From: Clive Jones [REDACTED]
Sent: 19 February 2016 13:43
To: Richard Price
Cc: Stinson, Lynne; John Russell
Subject: SUBMISSION BY CLIVE JONES ON BEHALF OF WOKINGHAM LIBERAL DEMOCRATS

SUBMISSION BY CLIVE JONES ON BEHALF OF WOKINGHAM LIBERAL DEMOCRATS
(Please refer to my previous representations -reference no 175)

Project	SMART MOTORWAYS PROGRAMME
	M4 JUNCTIONS 3-12
Drawing title	ENVIRONMENTAL MASTERPLAN
	REGULATION 4(2)(e)
	SHEET 13 OF 61
	CUTBUSH LANE OVERBRIDGE

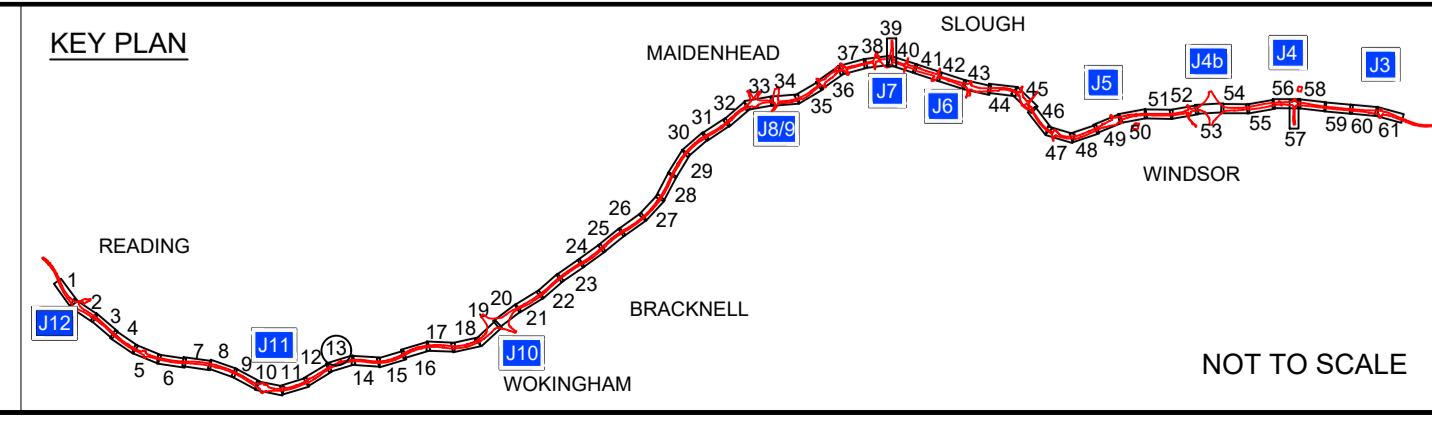
This is a 3-stage process involving a noise reduction test, a cost/benefit analysis, with 'professional judgement' thrown in to allow flexibility. The noise reduction criteria and the cost/benefit analysis hurdles must both be met for new or replacement barriers to be recommended. Between junctions 10 and 11 of the M4 there are very few replacement barriers. As I was able to point out on the accompanied site visits there are some fences which are there to keep people away from the motorway. Its somewhat disingenuous of Highways England to call them current barriers. I am thinking particularly of the barriers around the end of the Cutbush Lane area.

Project	SMART MOTORWAYS PROGRAMME
	M4 JUNCTIONS 3-12
Drawing title	ENVIRONMENTAL MASTERPLAN
	REGULATION 4(2)(e)
	SHEET 14 OF 61
	LOWER EARLEY

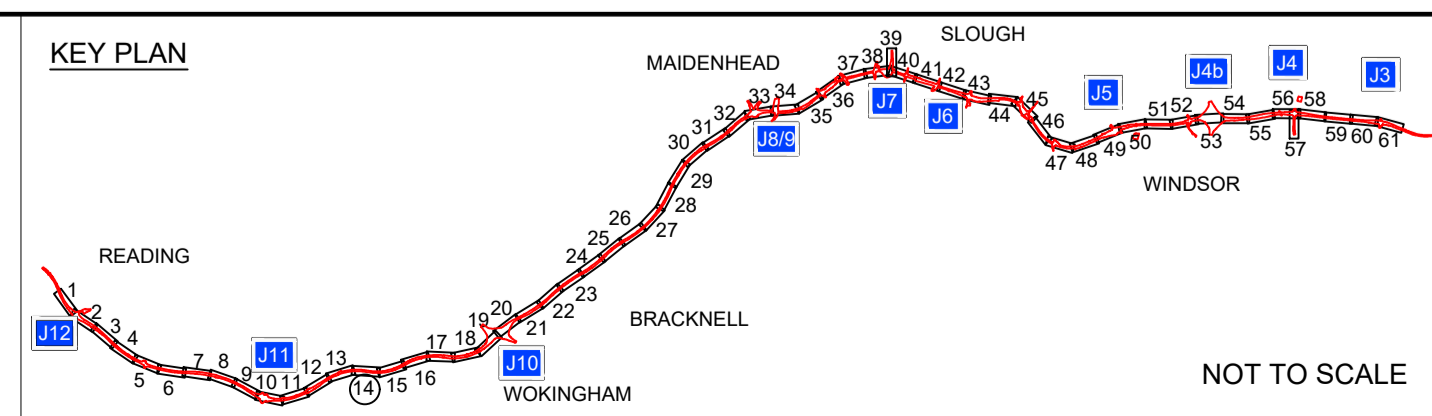
If we understand the data correctly, Lower Earley (EM8) passes the cost/benefit test at all barrier heights up to 4m, but passes the noise test only with 2.5 m high barriers. The tables show that the 2.5 m high barrier reduces noise by 4.7 dB (easily passing the test) but reduces noise by only 0.9 dB at the 3.0m barrier height (thus failing the test for this height by just 0.1 db.). Thus a 2.5m high barrier is recommended.

Moreover, if for some reason the noise reduction test is retained, what is the basis for the criteria used in the assessment? For example, why was 1.0 dB chosen as the criterion for an increase of 0.5 m increase in barrier height rather than 1.0 plus or minus 0.1dB? This minor change would have given Lower Earley a 3.0 m barrier rather than a 2.5 m barrier. The chosen criteria for success or failure seems arbitrary when compared with the well documented science based approach used in the cost/benefit analysis.
